RE: Thayer Shoreline Variance Application (SV-19-00001)

Enclosed are the comments received regarding the Shoreline Variance and SEPA (SV-19-00001, SE-19-00011) during the comment period:

**RE:** Thayer SEPA, SV 19-00001

Re: SV-19-00001, SE-19-00011

THAYER PROPERTY DEVELOPMENT
 FOR SINGLE FAMILY RESIDENCE
 SECTION AT MIDDLE OF BRIDGE
 DRAWING 5

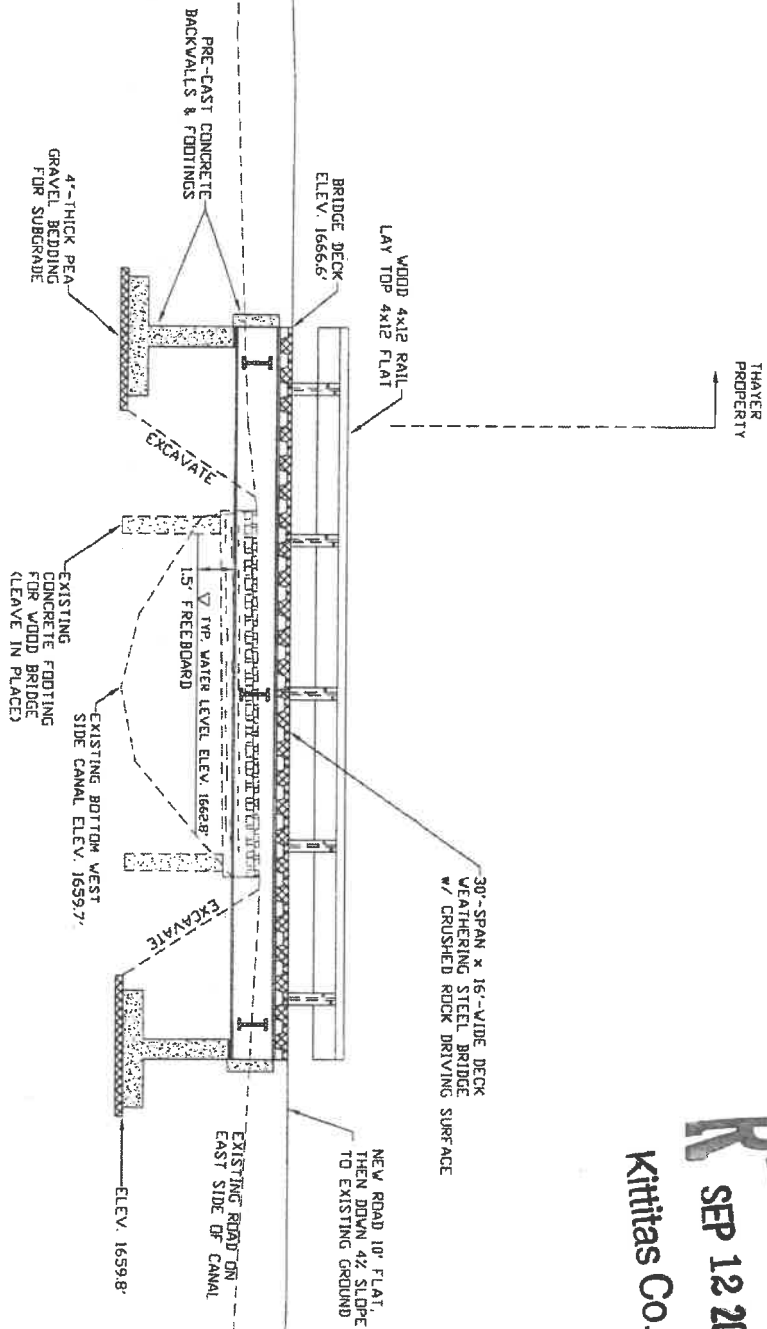
The new bridge will need to be posted for loads 75,000lbs + and meet minimum width requirements.

1. Applicant shall obtain a private bridge application from Public Works. Once received, Public Works will review engineering and provide final inspection of the proposed new private bridge.
2. A portion of the access driveway appears to be a candidate for widening within the delineated floodplain. Any fill in the floodplain will require a floodplain development permit. County code requires mitigation for floodplain fill.
3. The proposed parking area at the end of the driveway appears adequate meeting our required fire/life/safety turnaround.
